October 28, 2016

**Re: Weems Law Office - 108 Wellesley Dr., SE**  
**30-Day Temporary Certificate of Occupancy- Transportation Development**  
Architect's Stamp dated 1-25-16 (K16-D085)  
Certification dated 10-25-16

SITE PLAN / ROOF PLAN

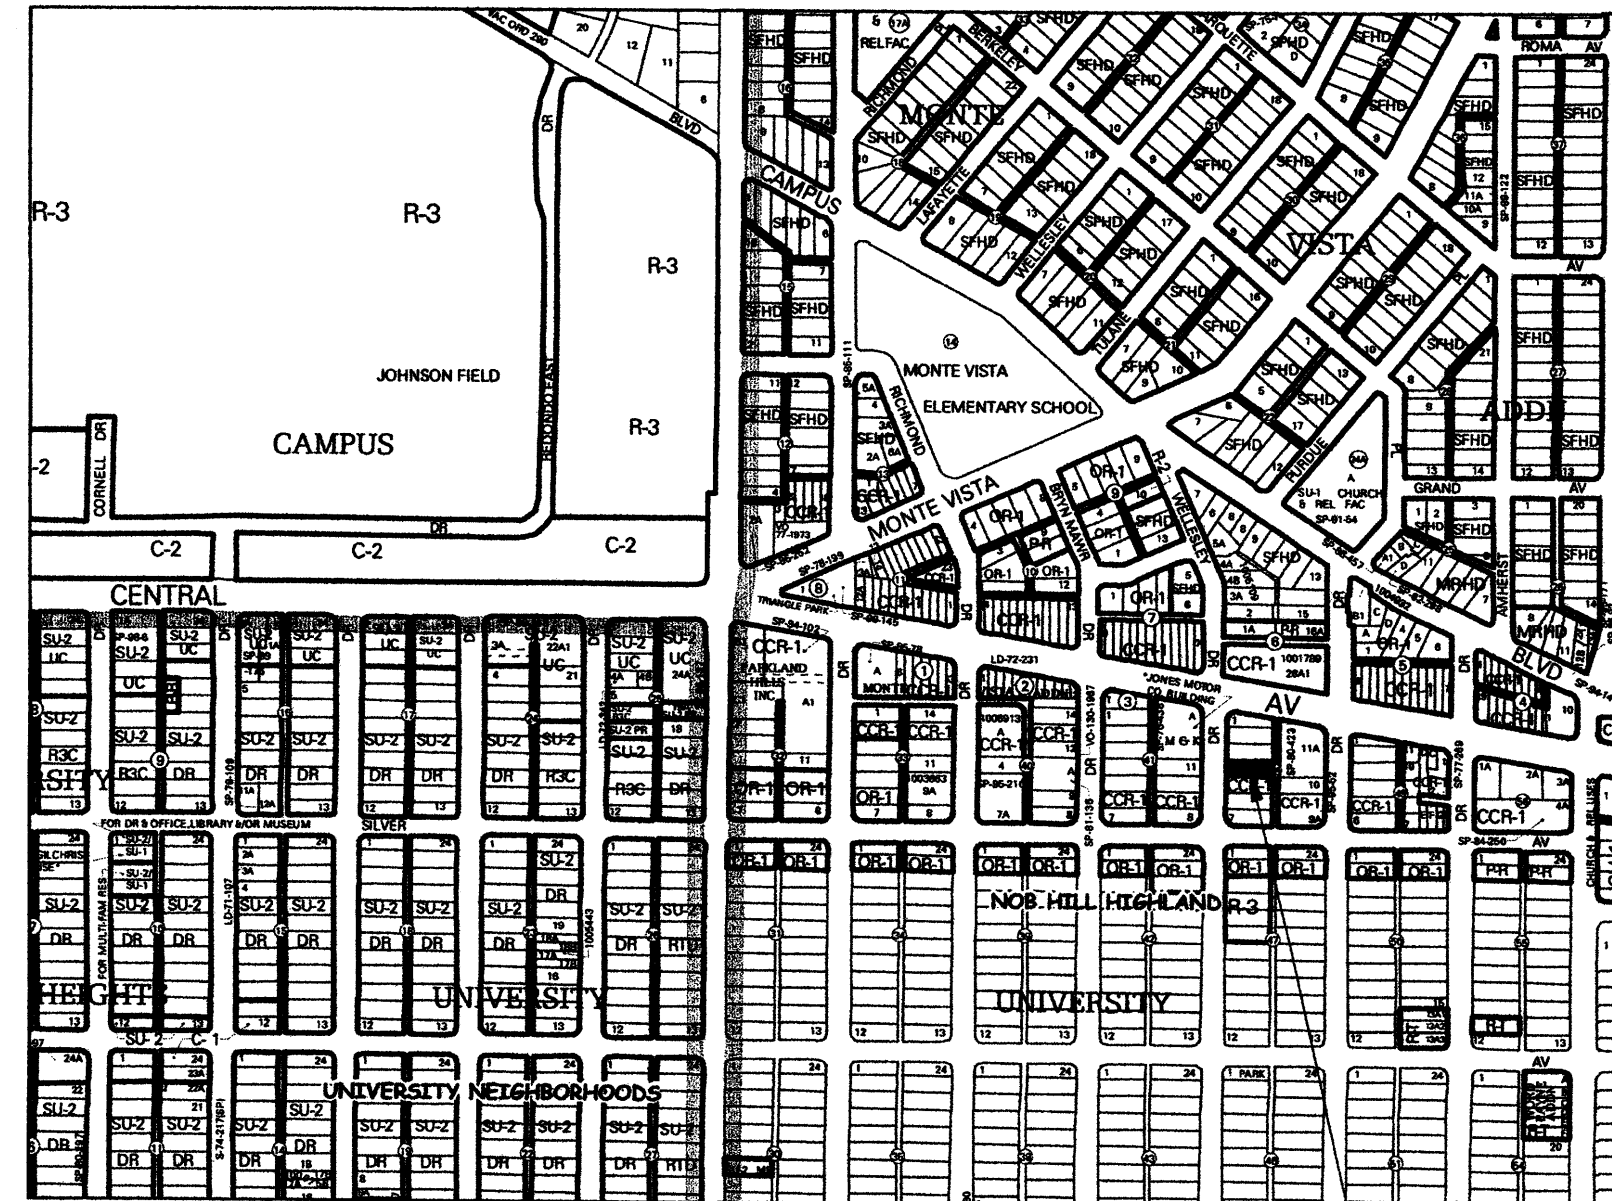
1. The ADA Van accessible parking sign is missing and must have the required language per 66-7-352.4C NMSA 1978 **"Violators Are Subject to a Fine and/or Towing."** Please call out detail and location of HC signs.
2. The ADA access aisles shall have the words **"NO PARKING"** in capital letters, each of which shall be at least one foot high and at least two inches wide, placed at the rear of the parking space so as to be close to where an adjacent vehicle's rear tire would be placed. (66-1-4.1.B NMSA 1978)
3. The ADA parking space must have a clearly visible, blue International Symbol of Accessibility painted on the pavement at the rear of the space (66-1-4.1.E NMSA 1978) or MUTCD recommends a white symbol on a blue background.

*ENTRY DRIVE ON WELLESLEY IS 32'-7", north curb cut left as existing  
HANDICAP AISLE ON EAST SIDE IS 5' WIDE  
EAST WALKWAY IS 4'-0" WITH PLANTING AREA BETWEEN WALK  
AND PARKING  
NO PARKING SIGN ADDED ON ASPHALT BETWEEN THIS PROPERTY  
AND PROPERTY TO NORTH*
